# Advice to decision maker on coal mining project

### IESC 2015-062: Mount Owen Continued Operations Project (EPBC 2013/6978; SSD 5850) – Expansion

Requesting agency	The Australian Government Department of the Environment The New South Wales Department of Planning and Environment
Date of request	27 January 2015
Date request accepted	27 January 2015
Advice stage	Assessment

FIGURE 5.1
Conceptual
Final Landform

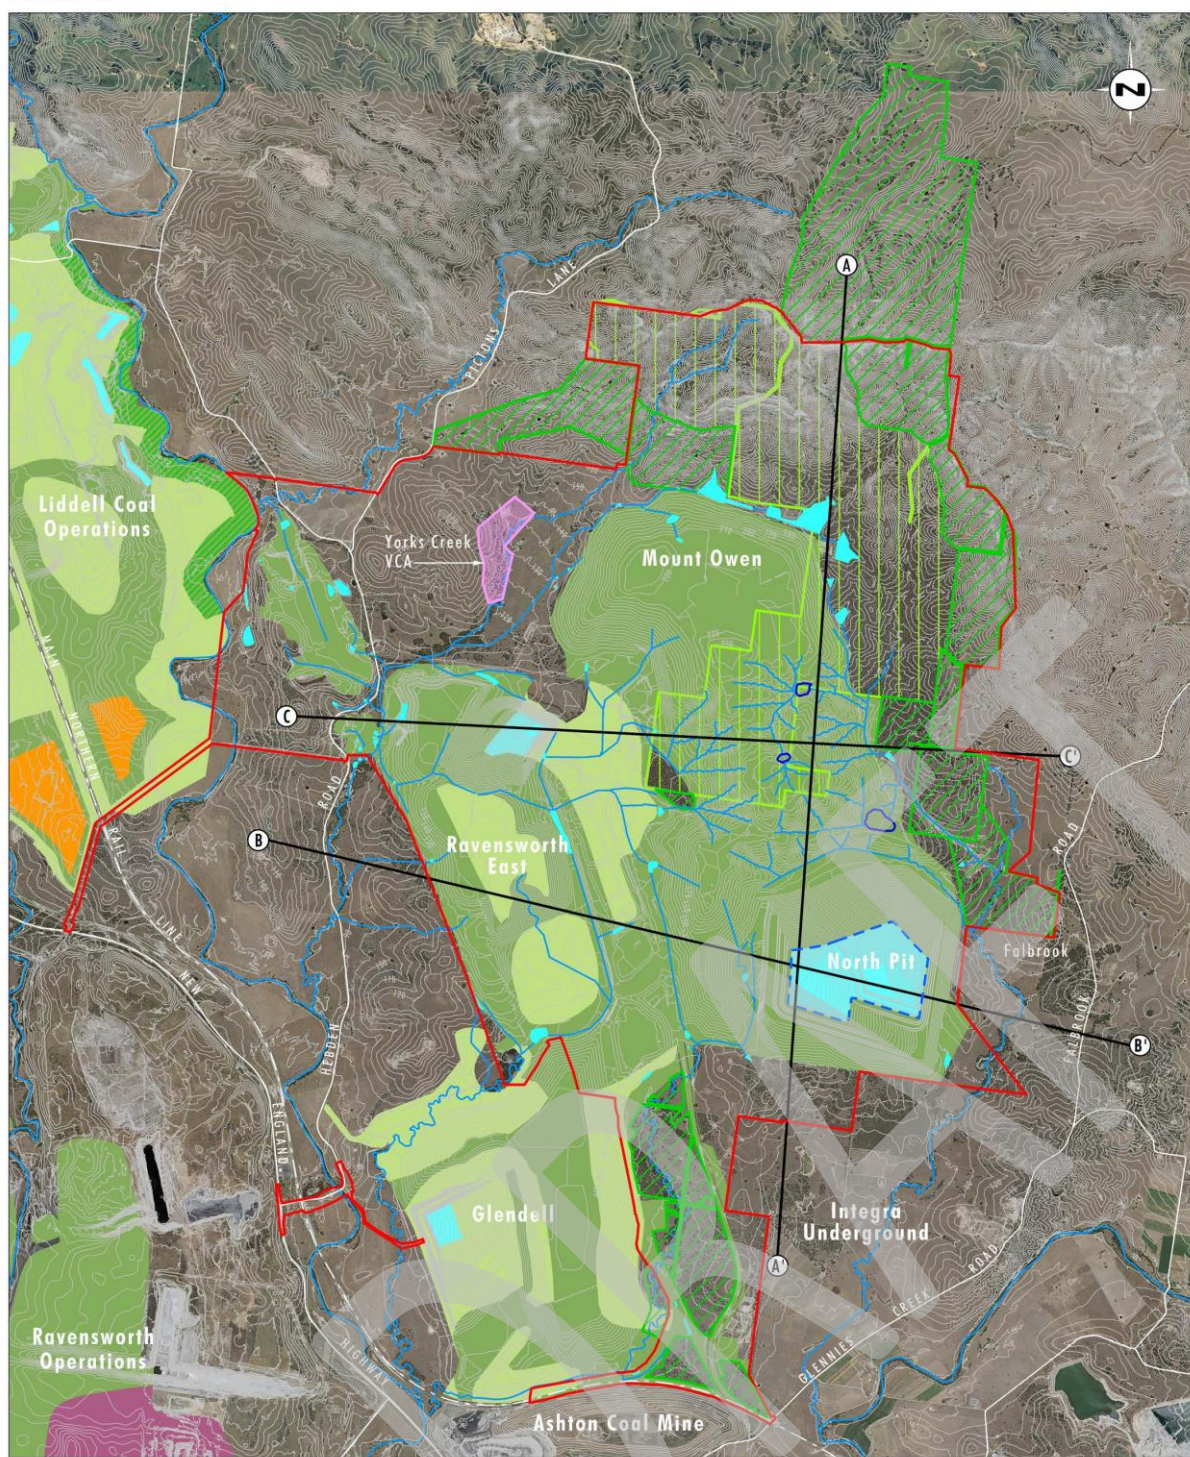
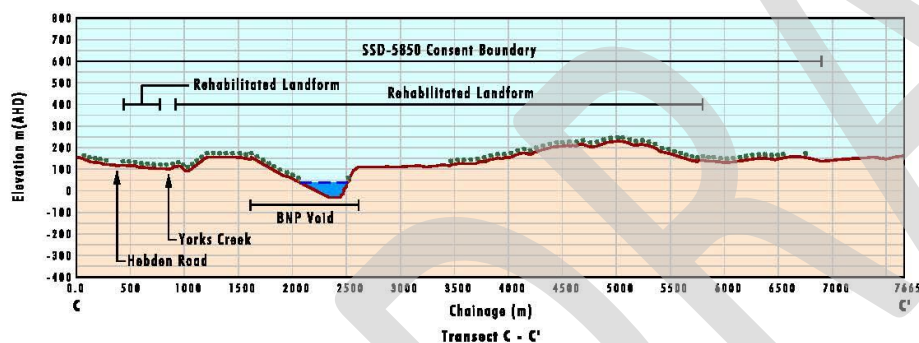
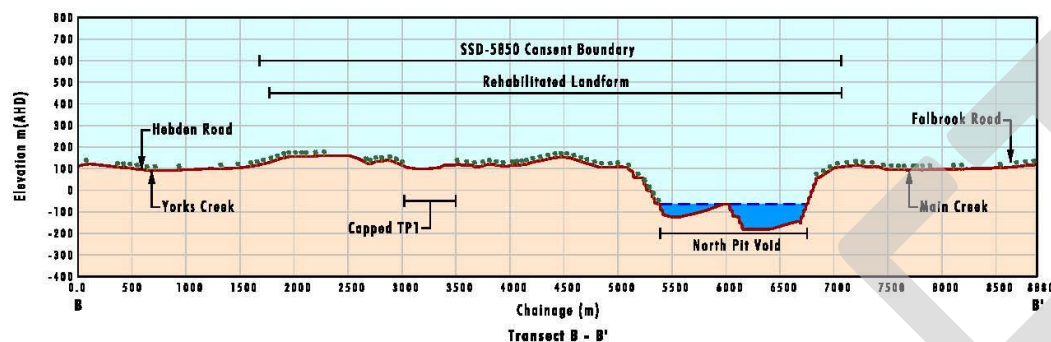
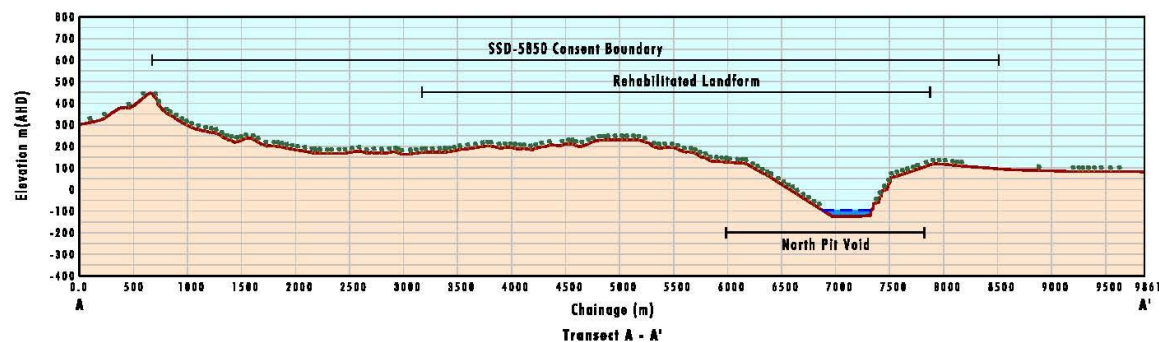
- 25. The final landform, in its current conceptual form, following the completion of the proposed project contains three final voids. The proponent has identified the key rehabilitation and final landform design criteria in their Mine Closure and Rehabilitation Strategy. This report will need to be updated to demonstrate that the legacy issues and risks to water resources as a result of the final

landform have been assessed and will be adequately mitigated and managed. This will need to include:

- a. the design of a post-mining groundwater and surface water monitoring network to provide a representative indication of groundwater and surface water quality to identify any leaching of saline or acidic material
- b. an assessment of the potential risks to regional hydrogeological units and surface watercourses caused by potential leakage or connectivity from the NPE final void into the underlying goaf of the Integra underground operations.
